KITTITAS COUNTY

DEPARTMENT OF PUBLIC WORKS

MEMORANDUM

TO: All Staff
FROM: Public Works Plan Review Team
DATE: November 13, 2025
SUBJECT: SP-25-00011 Hubbard

HUBBARD SHORT PLAT PART OF SECTION 6, T. 17 N., R. 20 E., W.M. KITITAS COUNTY, WASHINGTON

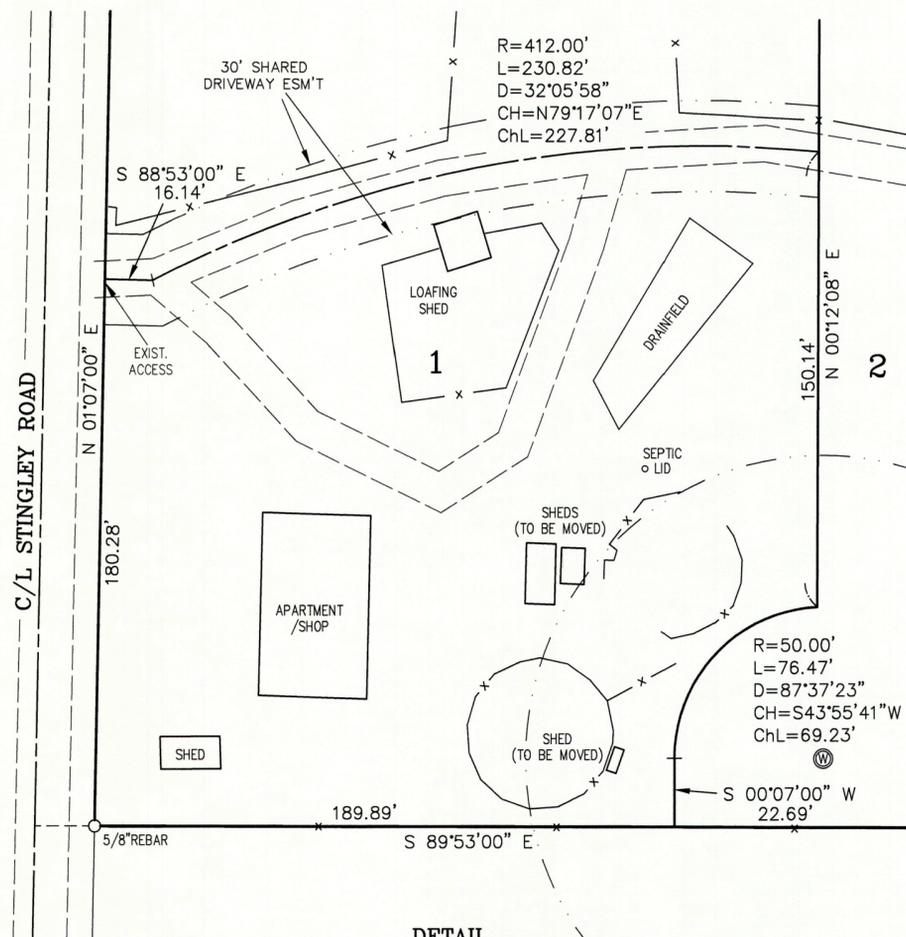
SURVEY	<ol style="list-style-type: none"> 1. Basis of bearings needs to be called out. 2. Recording number for Driveway easement – Existing or proposed? 3. Notes 1 and 2 on page 2 are overlapping. <p>(DF)</p>
TRANSPORTATION CONCURRENCY	<p>No transportation concurrency requirement for this project. (RC)</p>
FLOOD	<p>Parcel #200533 is not within the FEMA identified special flood hazard area (100-year floodplain). A floodplain development permit is not required for the project. (SC)</p>
